NEAR NORTH VALLEY NEIGHBORHOOD ASSOCIATION

January 18, 2022

Re: Brown Property (Calle Cuarta) redevelopment
PR-2020-003847; site plan for the East Parcel

SHEET NO.
SDP1.1
 OF

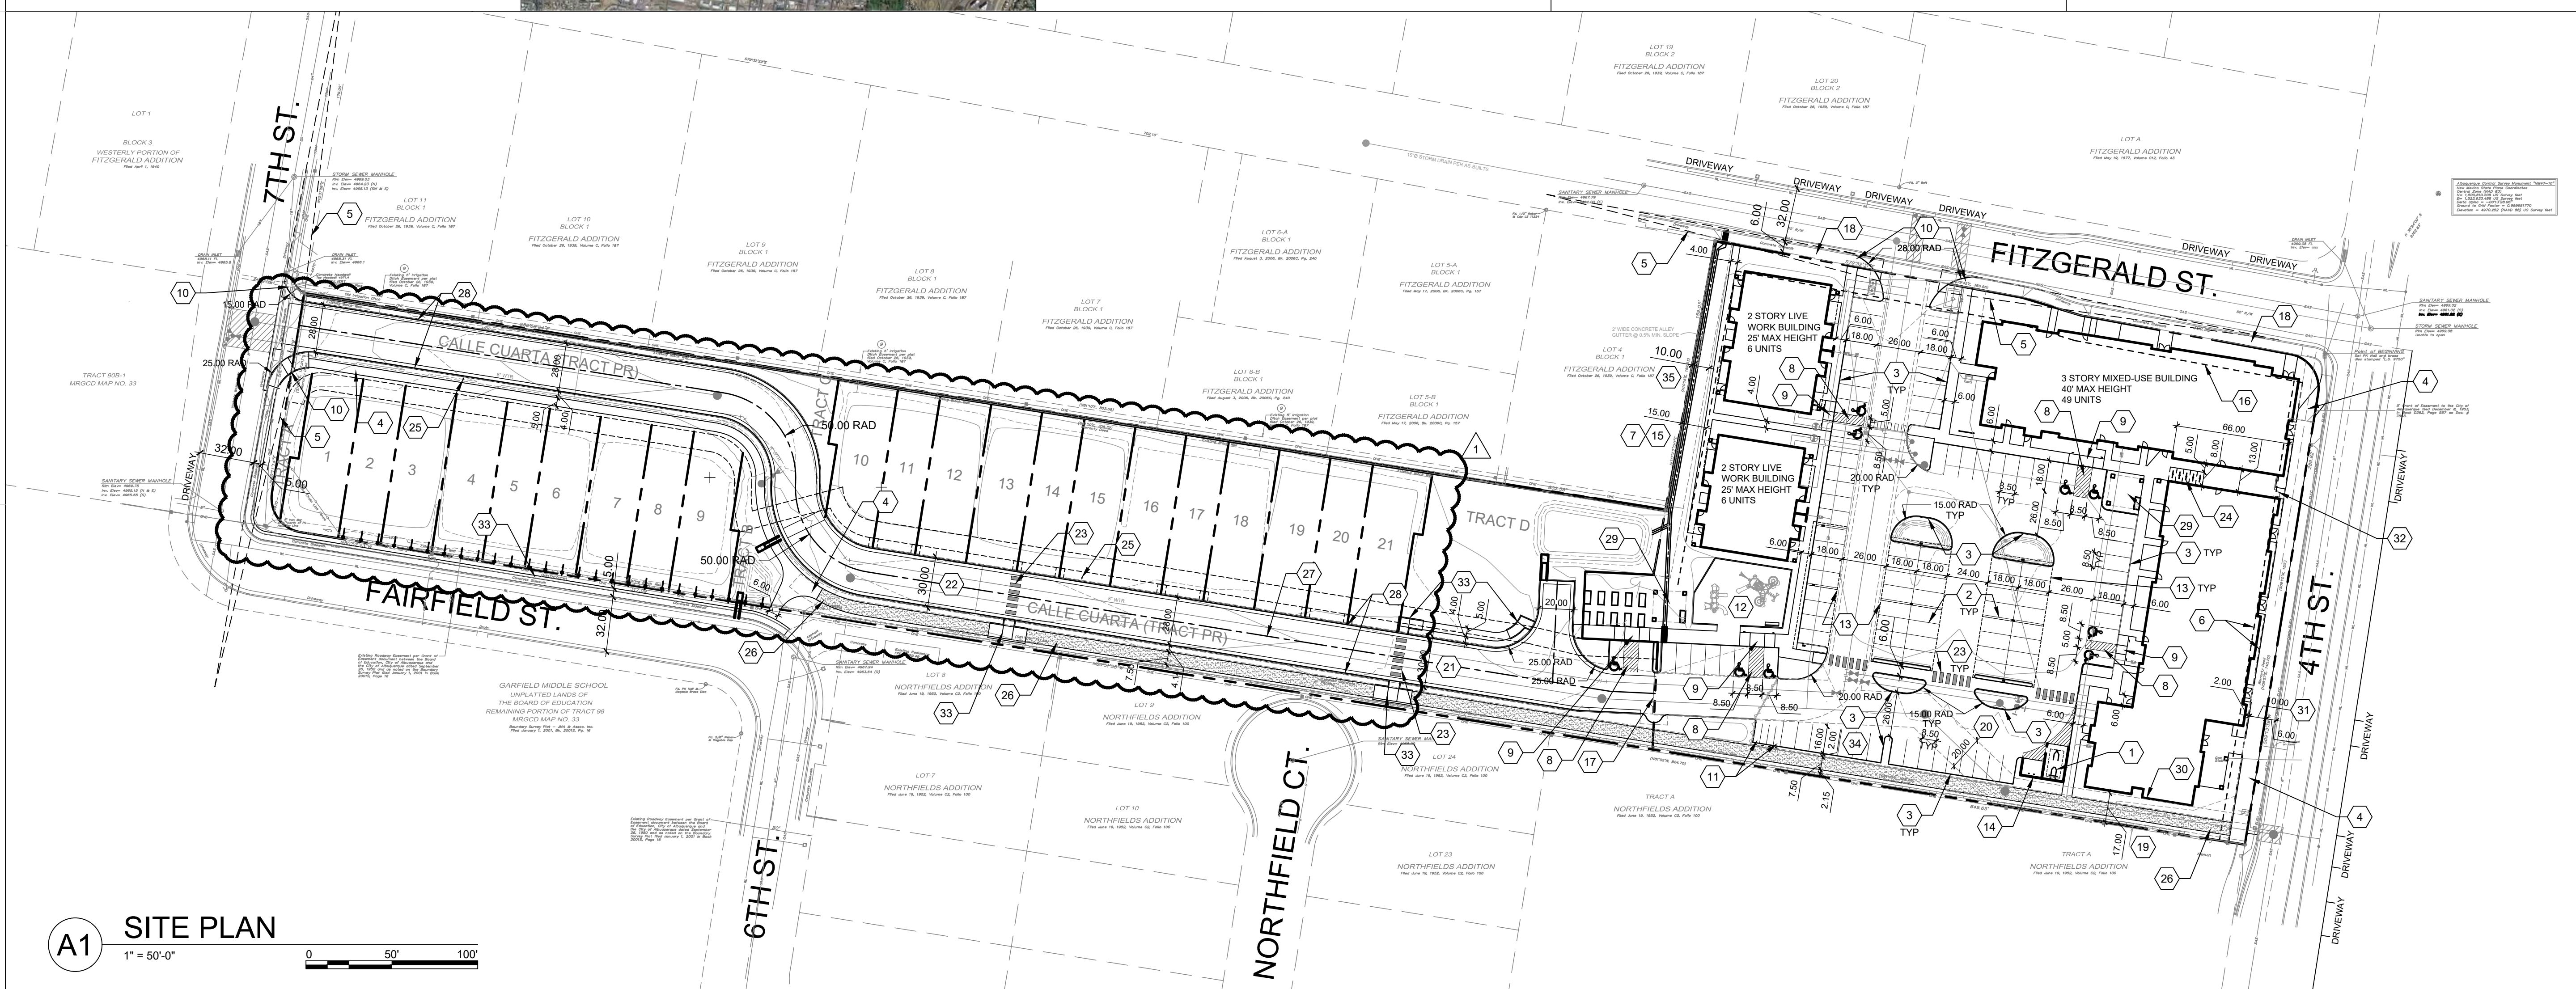
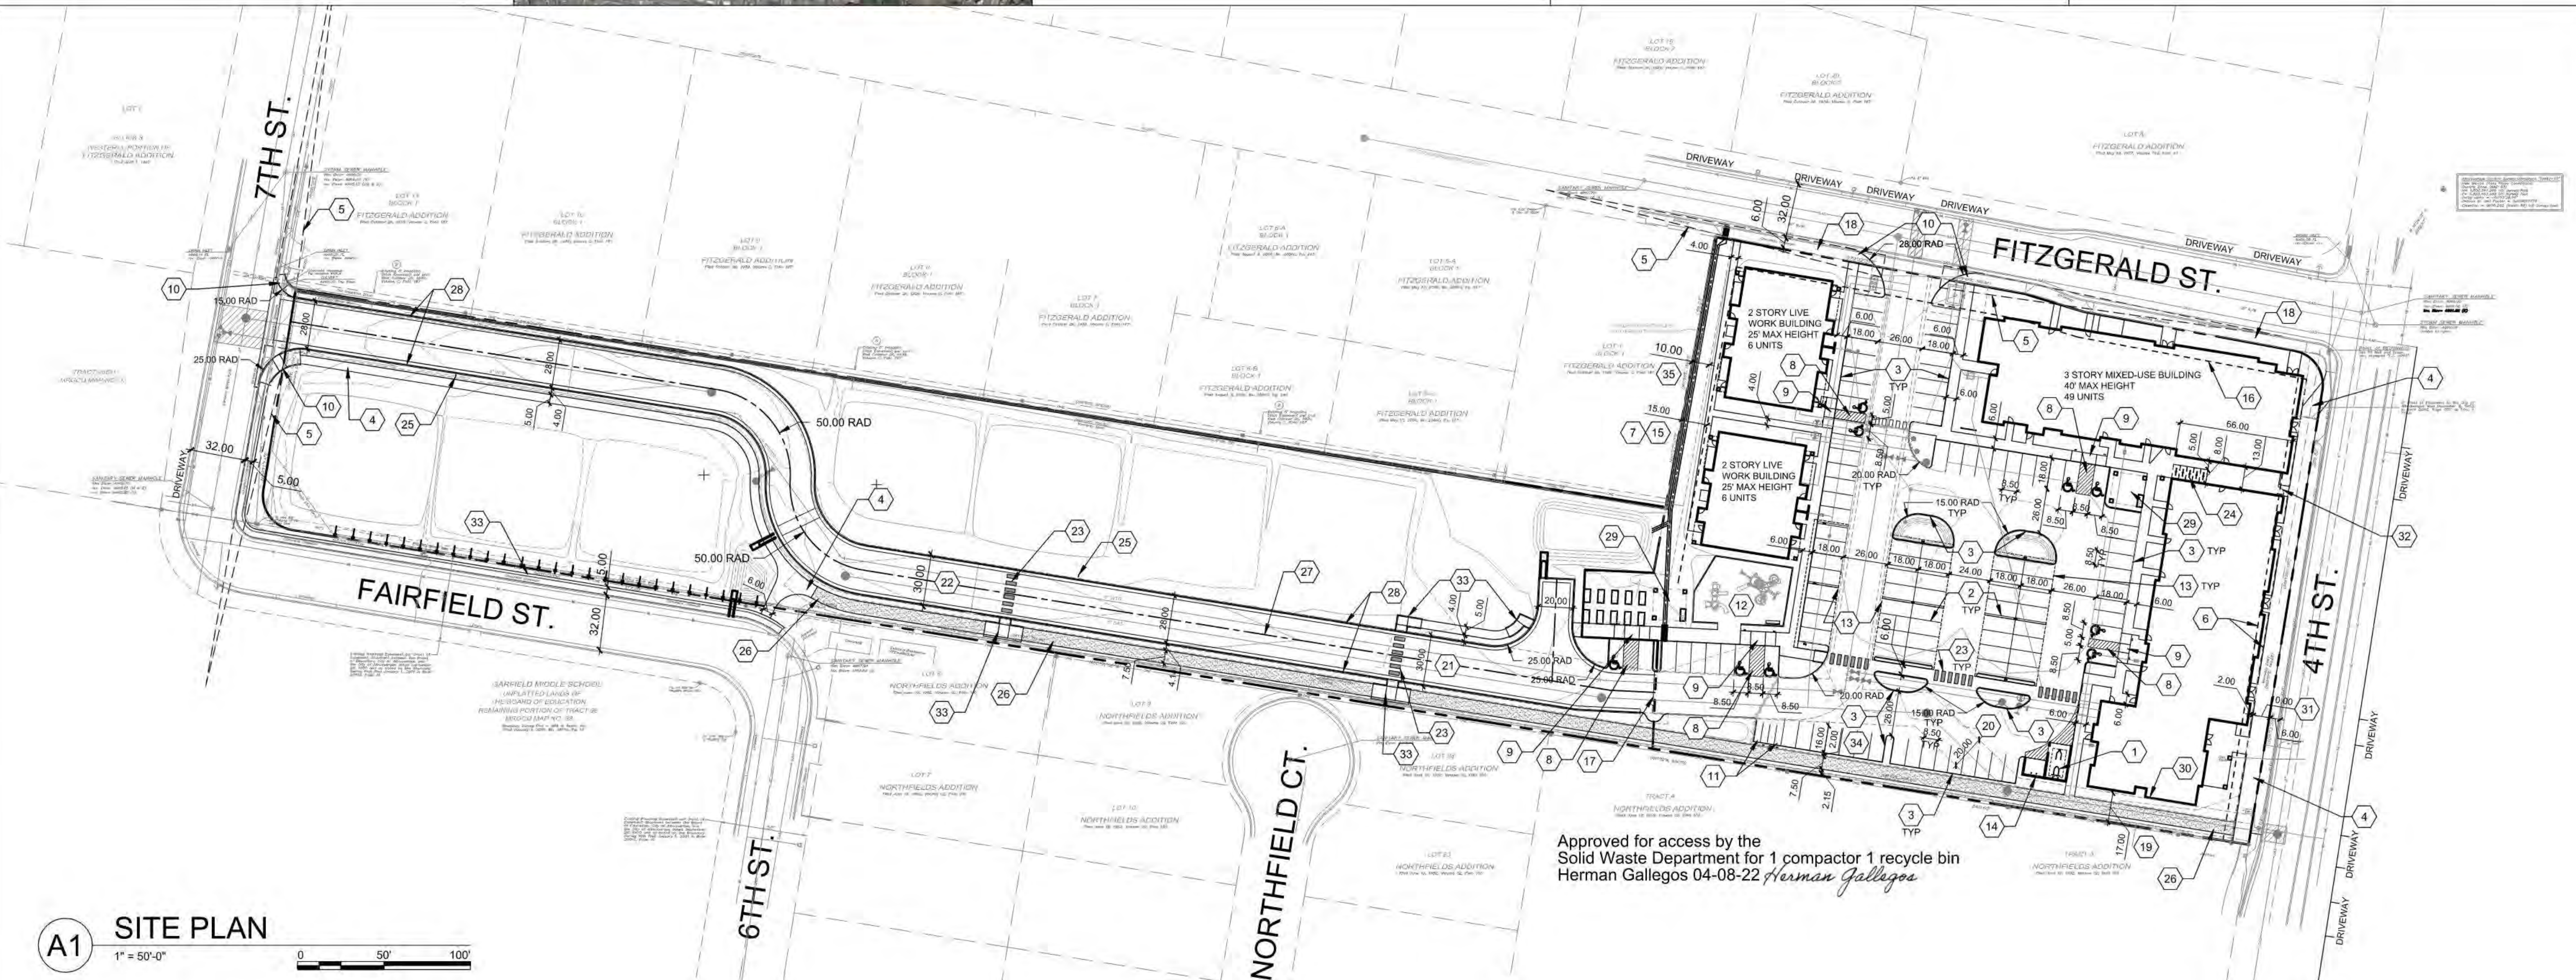
We appreciate that the applicant's Supplemental Submittal dated January 14, 2022, includes an additional note on SDP1.1 indicating that an emergency-access-only gate is to be installed between the East and West Parcels. The note is numbered "17." The note next to the gate, however, is numbered "8." This is just a typo, for sure, but it needs to be corrected so there's no question.

The Jan 14, 2022, Supplemental Submittal indicates that two handicapped parking spaces have been added near the community open space/play area. None of the handicapped parking, however, is covered.

SITE PLAN - DRB

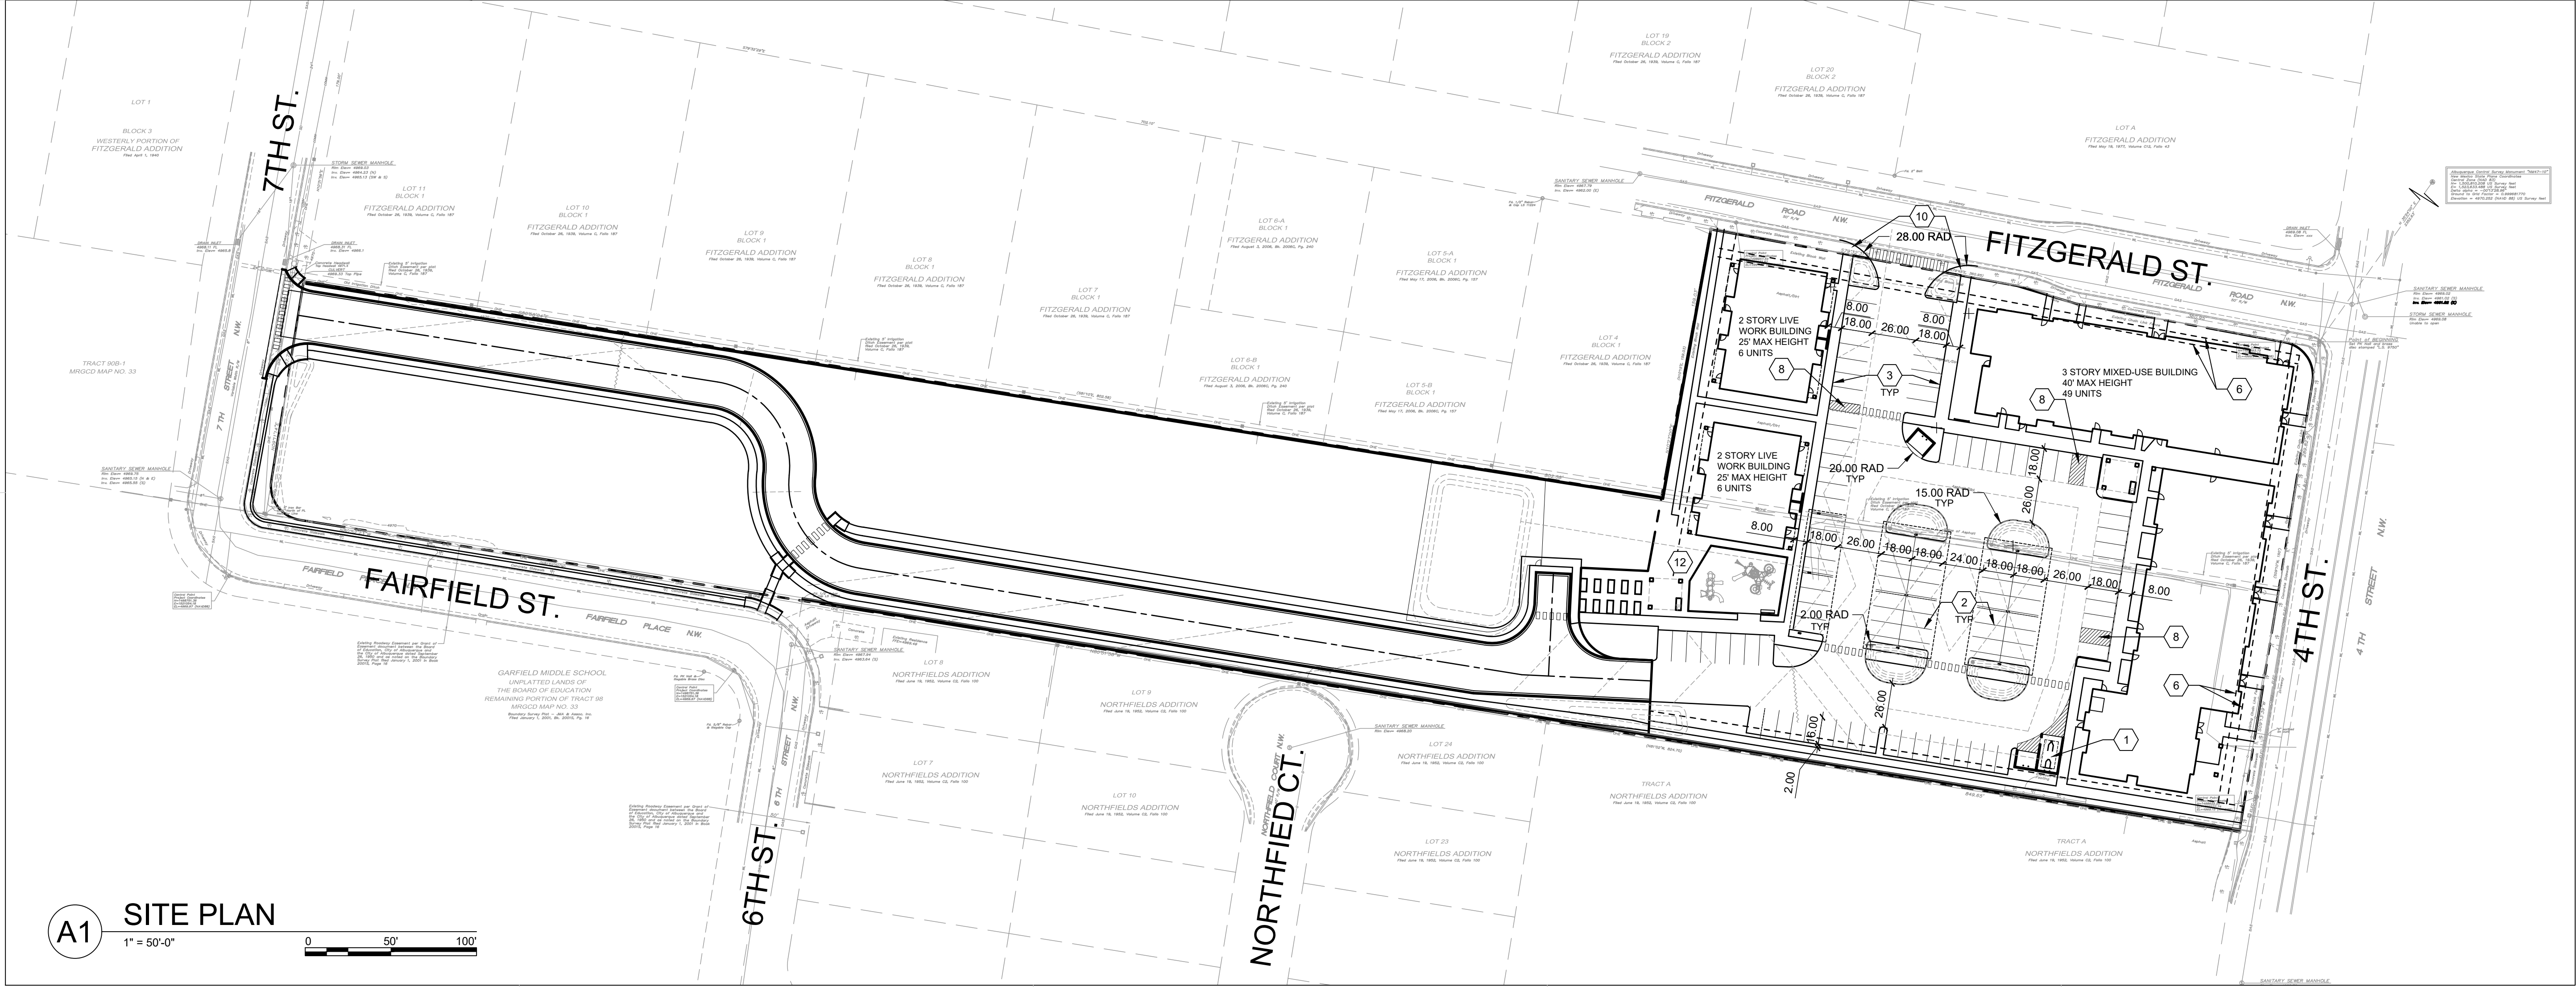
We believe the current design for the 4th Street streetscape does not meet City requirements. This stretch of 4th Street is within the City's North 4th Corridor Character Protection Overlay zone (CPO-9), which requires that all development comply with DPM requirements related to transportation design standards, including street cross sections (IDO 14-16-3-4(J)(4)(b)). The DPM requires that cross sections developed as part of a City-approved planning process or study within the past 10 years be used as the basis for development (DPM 7-3(C)(6)(ii)). The City's North Fourth Street Redevelopment Study, dated November 26, 2014 (copy attached; also available at cabq.legistar.com/Legislation.aspx as Appendix 1 to R-19-162), includes a desired profile for this stretch of 4th Street. This profile, identified as the "Proposed Ultimate Typical Section" (page 6), calls for a landscape buffer between the curb and sidewalk.

This stretch of 4th Street also is a designated "Main Street" area. As such, a 10- to 12-foot sidewalk width is required (DPM Table 7.2.29), and where that

sidewalk is next to the curb, a 12- to 14-foot sidewalk width is required (DPM 7-4(E)(1)(iii)(4)).

It appears from the last and current rendering that the proposed streetscape is neither practical nor sustainable and possibly not ADA-compliant. Based on the *rendering*, it appears that other than the existing sidewalk, there are no concrete landings at the doorways of the businesses, and no concrete pathways to those doorways. There does appear to be a concrete pathway to the breezeway. It's possible to read the *site plan* itself differently, but there are no notes confirming that the pathways from the sidewalk to the doorways are concrete (nor how they satisfy ADA) nor is the concrete pathway to the breezeway indicated on the site plan.

We again request that a detailed profile of the 4th Street streetscape—from curb to building—be provided so that this important frontage can be properly evaluated by the DRB.

**A1 DRB BUILDING 1 - SOUTH**  
3/32" = 1'-0"

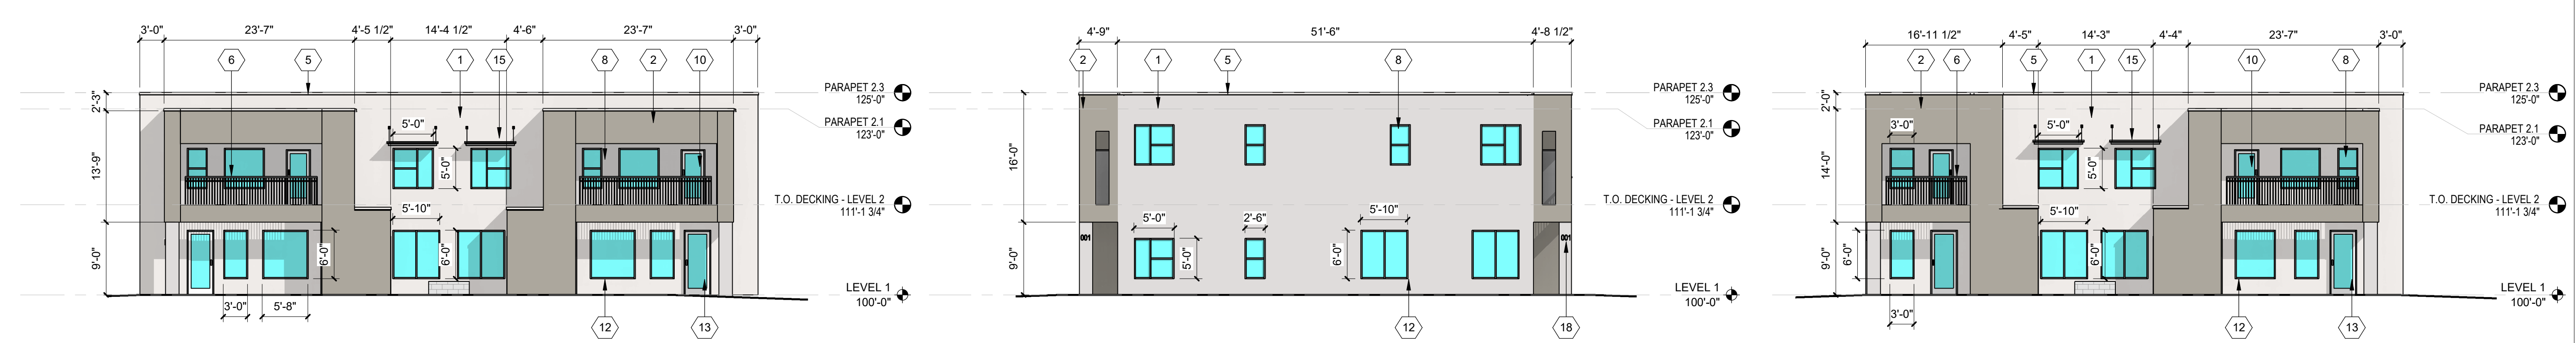
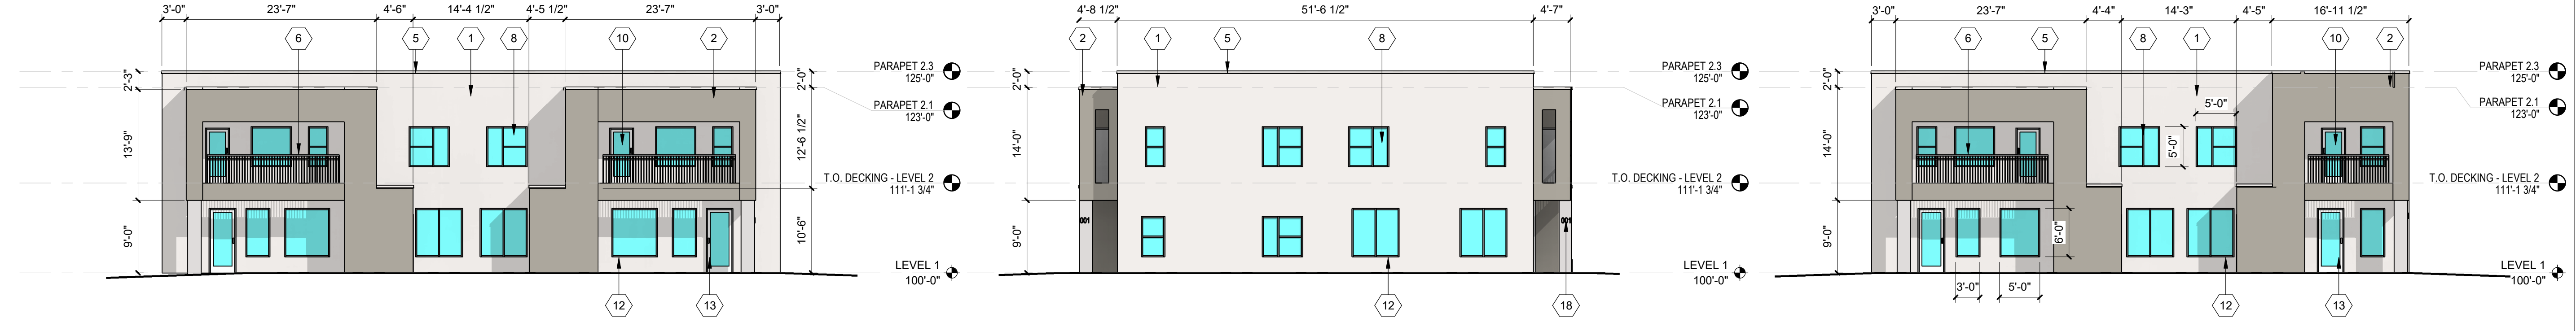
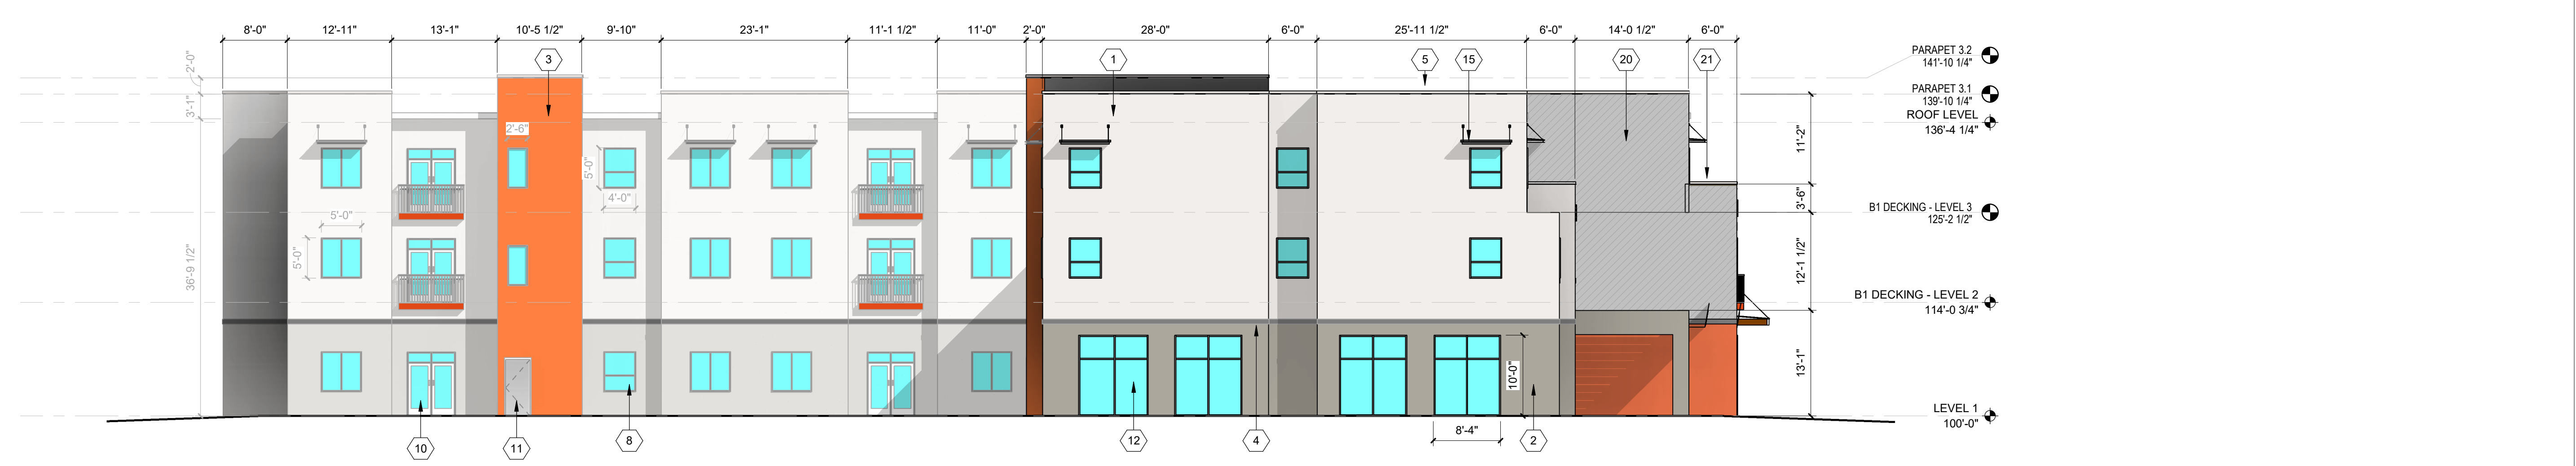
We accept the DRB's conclusion that step-backs are not required along Fitzgerald Road. We still question whether the articulation, particularly on the westernmost block of apartments along Fitzgerald and the southern face of the building next to the tire store, meets the Main Street façade requirements under IDO 14-16-5-11(E)(2)(b), including the requirement for recessed windows on upper floors.
